Application Ref:	3/2025/0920			 Ribble Valley Borough Council www.ribblevalley.gov.uk				
Date Inspected:	N/A	Site Notice:	N/A					
Officer:	EP							
DELEGATED ITEM FILE REPORT:					APPROVAL

Development Description:	Certificate of Lawfulness for proposed single-storey extension to rear.
Site Address/Location:	34 Bracken Hey, Clitheroe BB7 1LW.

Drawing Title
PROPOSED FLOOR PLANS, SITE PLAN AND ELEVATIONS.

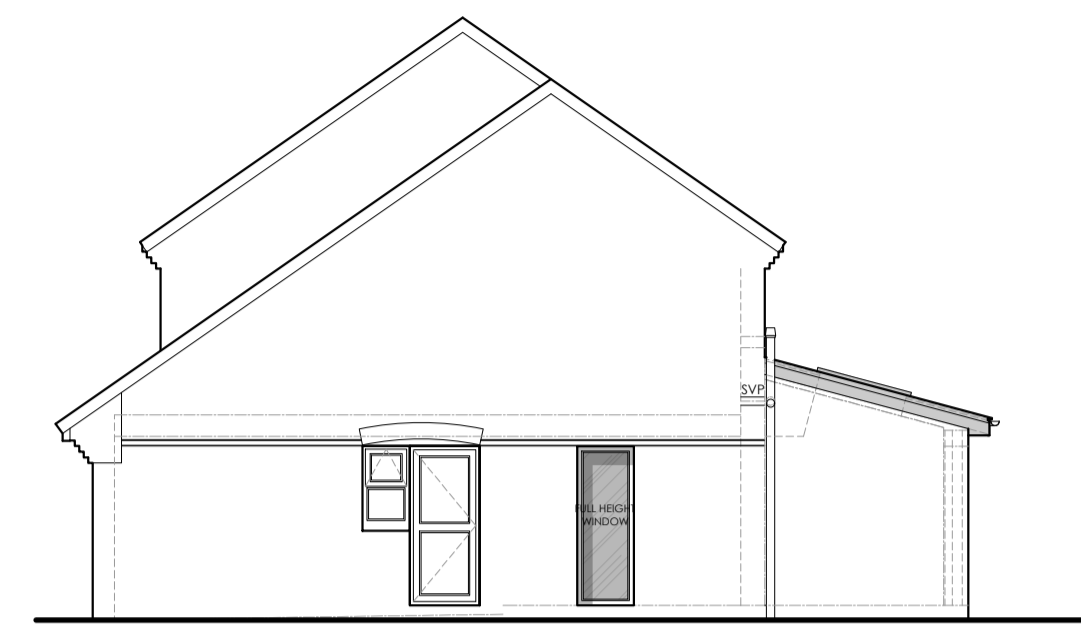
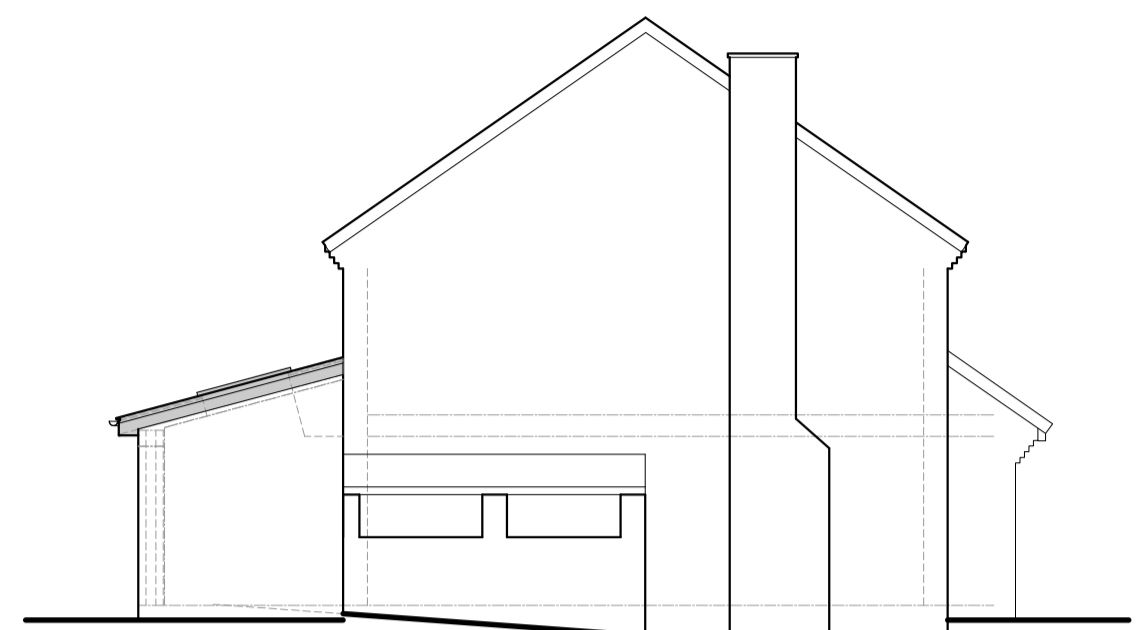
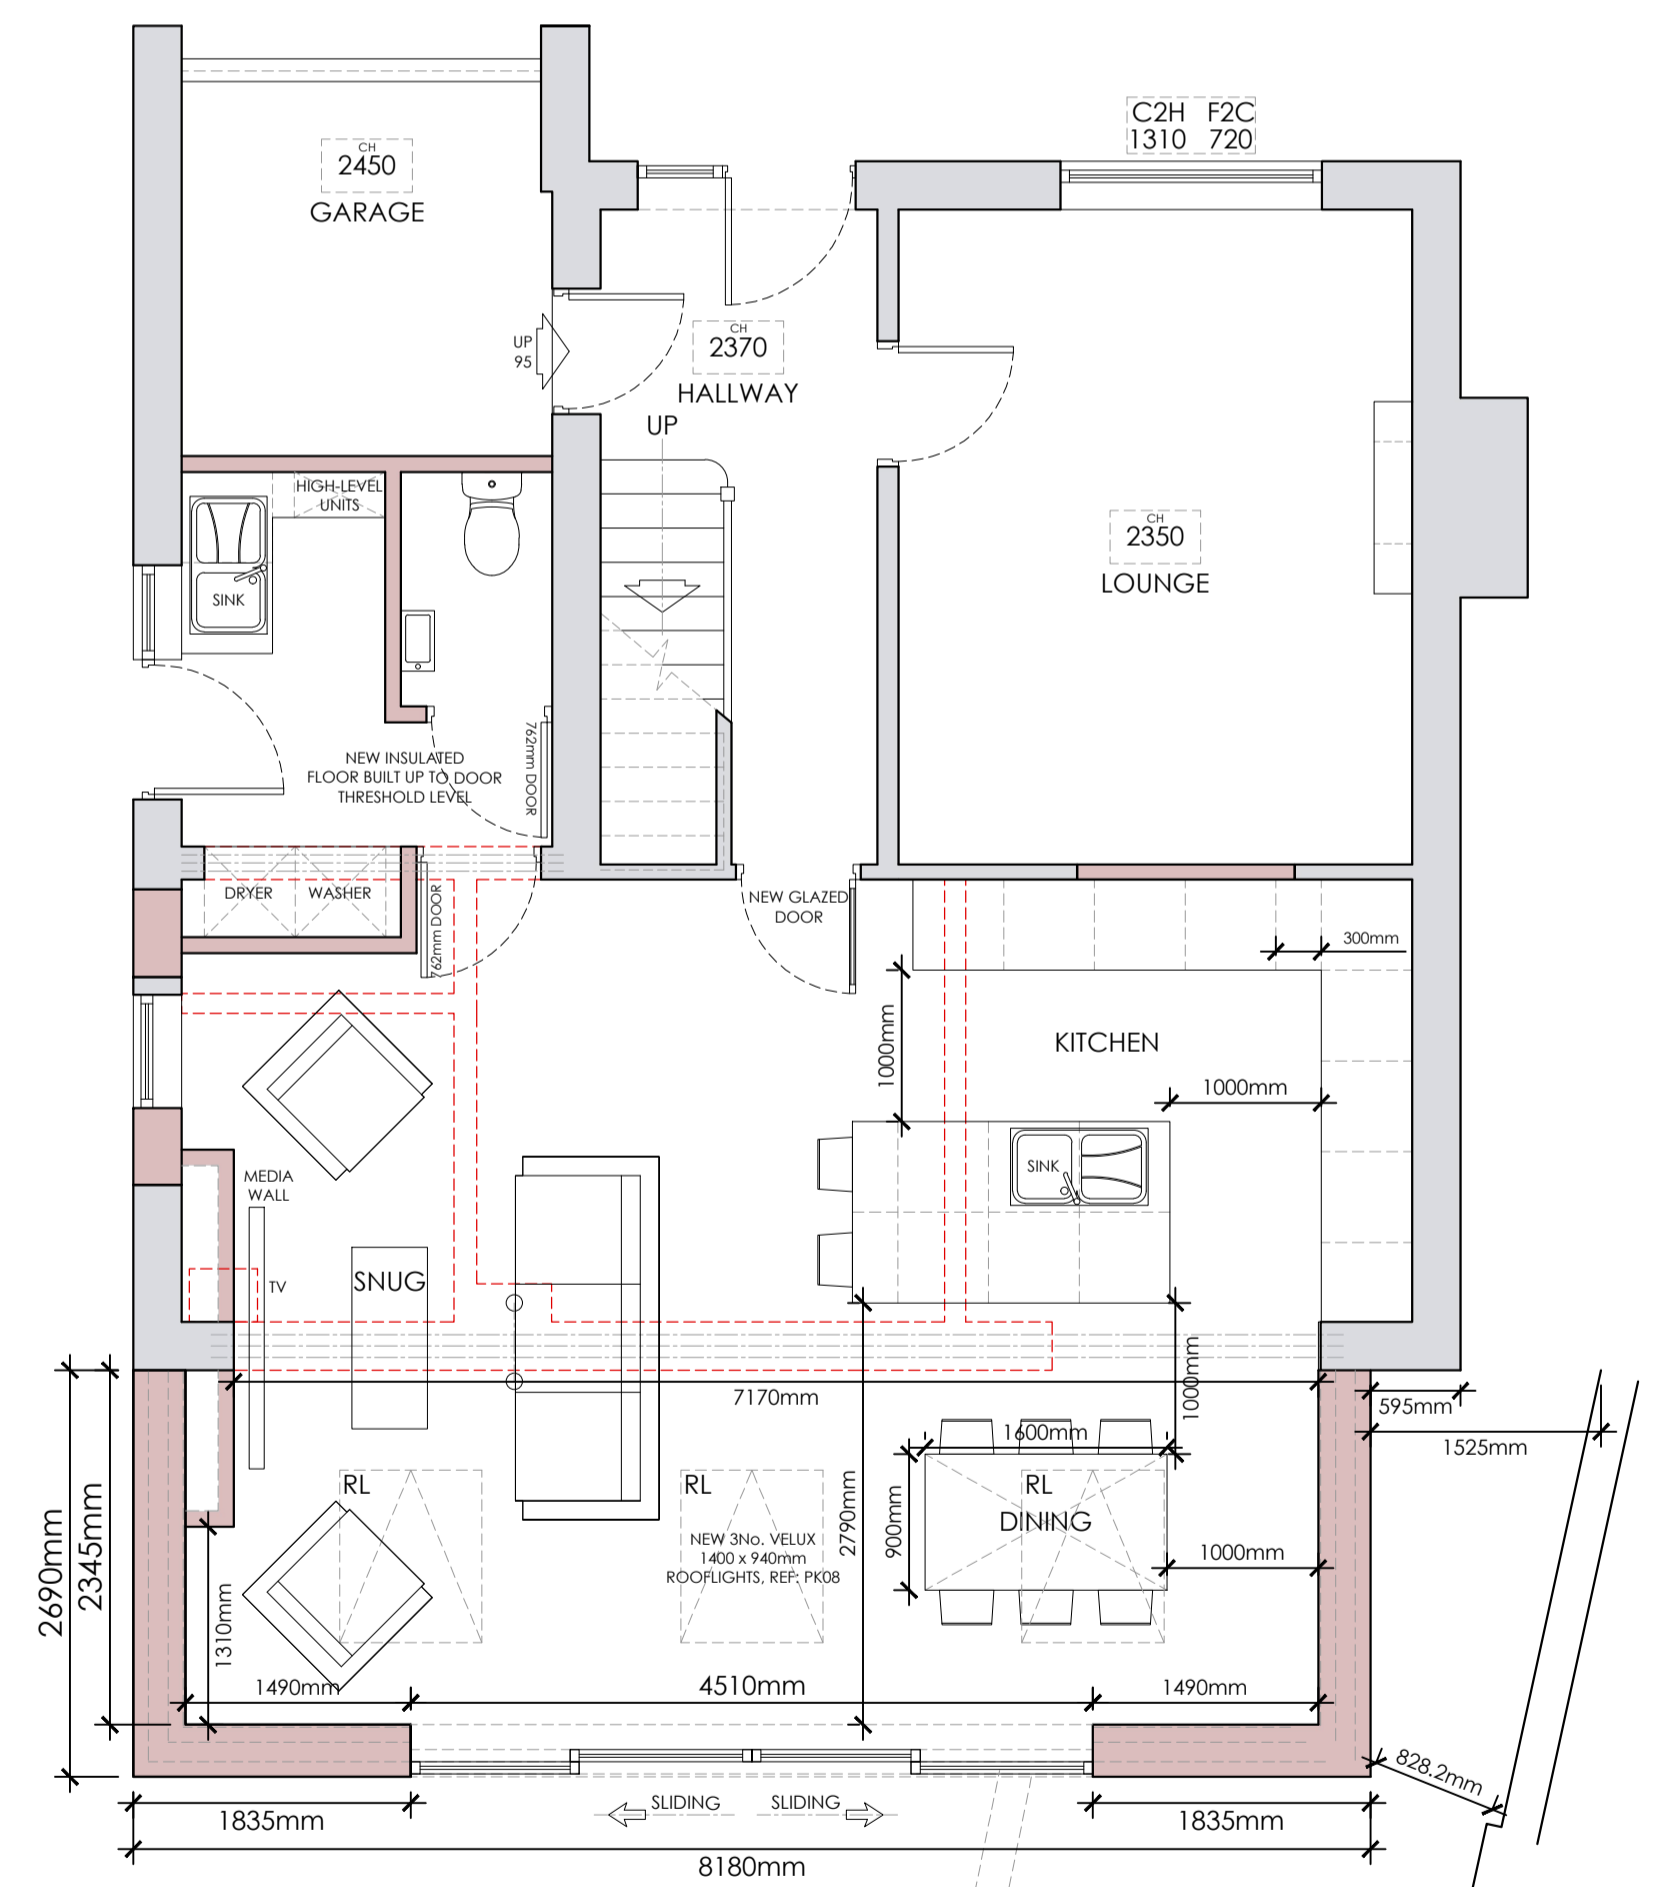
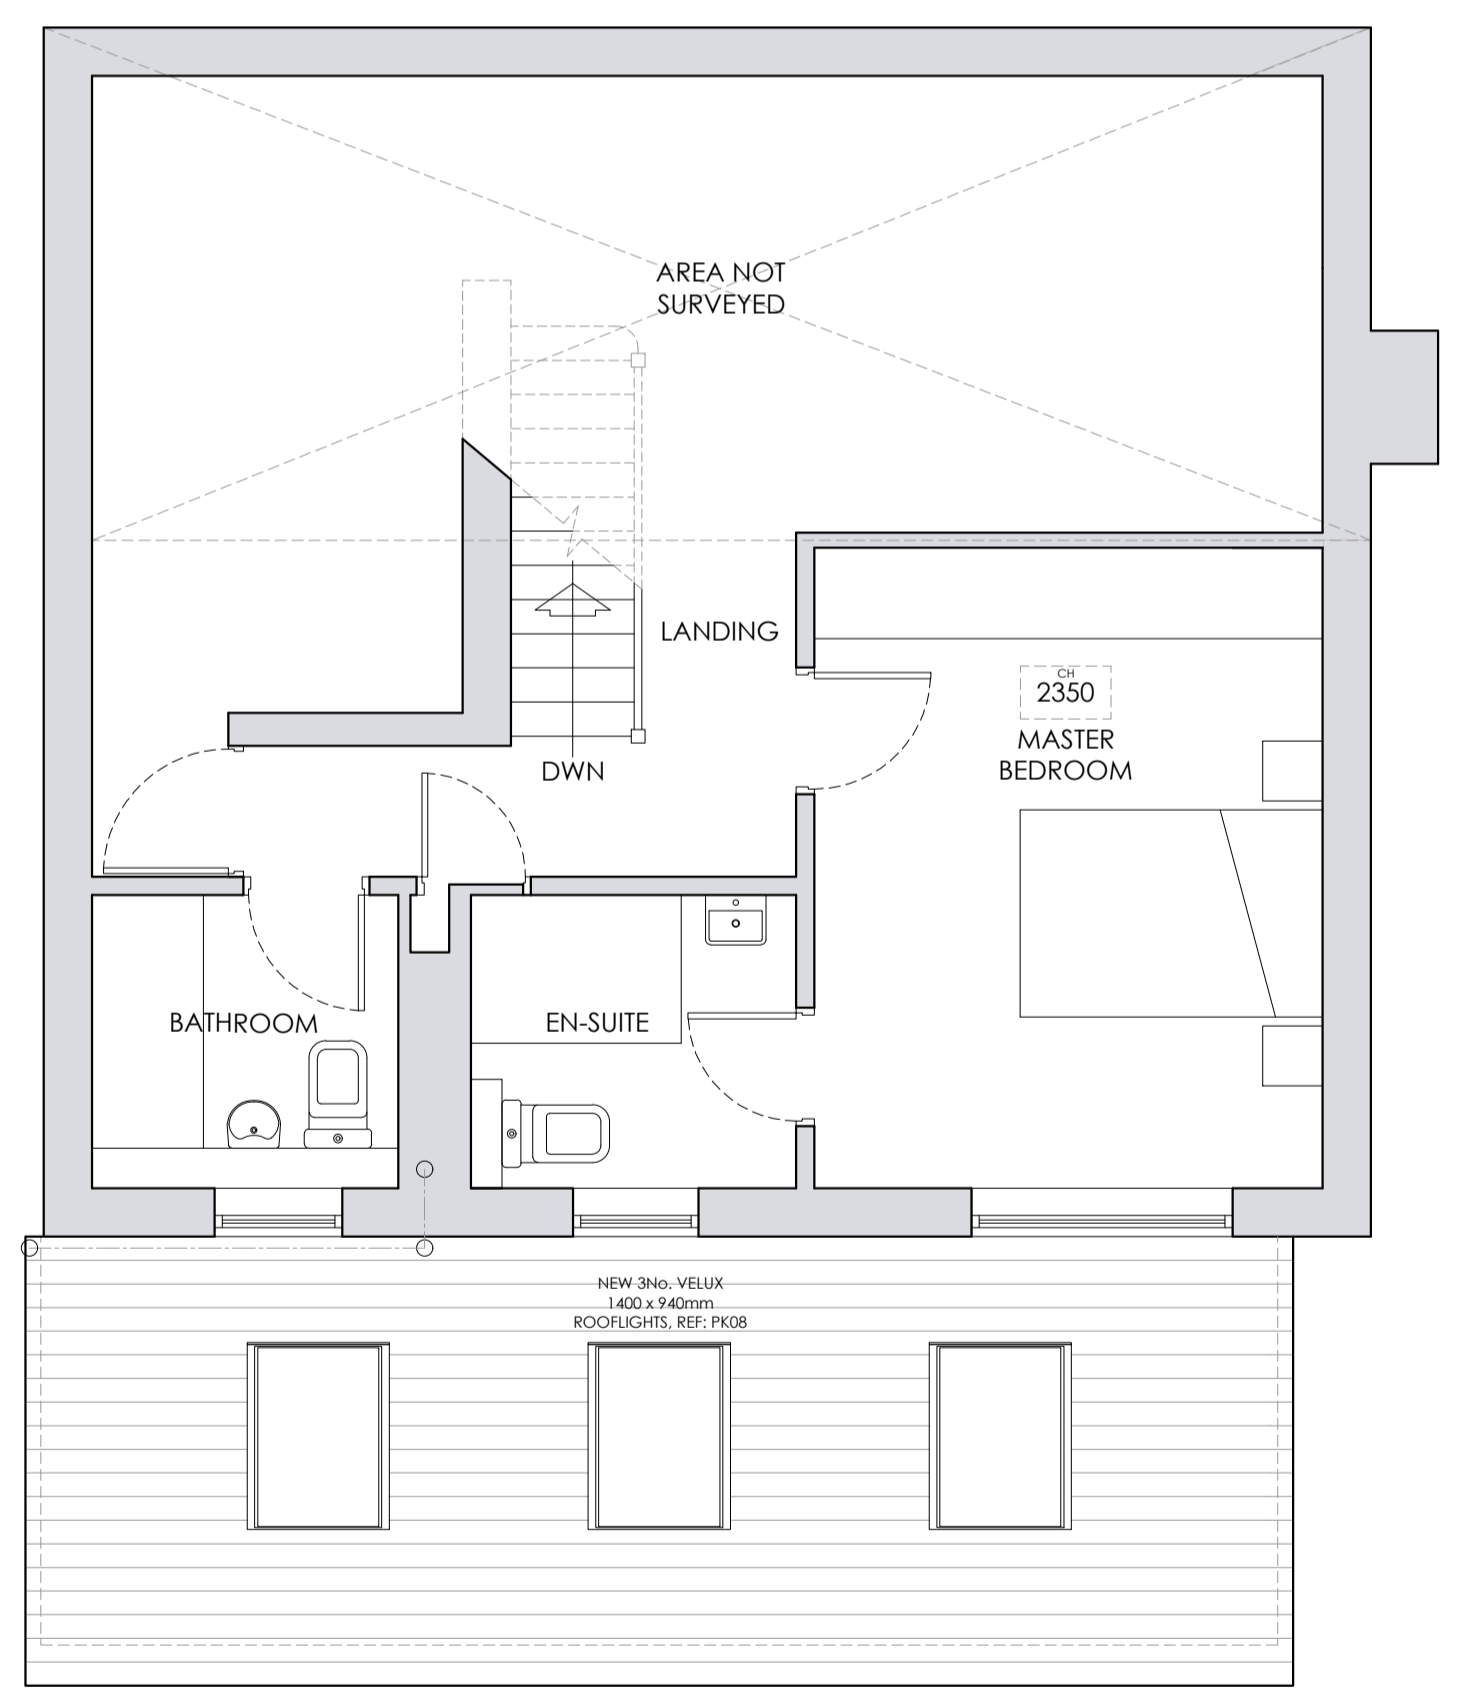
The proposed single storey extension will extend beyond the rear elevation of the dwelling by 2.7m metres and will measure 3.47 metres in height.

The proposed single storey extension will measure 2.67 metres in height to the eaves.

The proposed extension will be constructed in brickwork to the elevations with concrete rooftiles, this is consistent with the application dwelling.

The proposal meets the above criteria to be classed as permitted development.
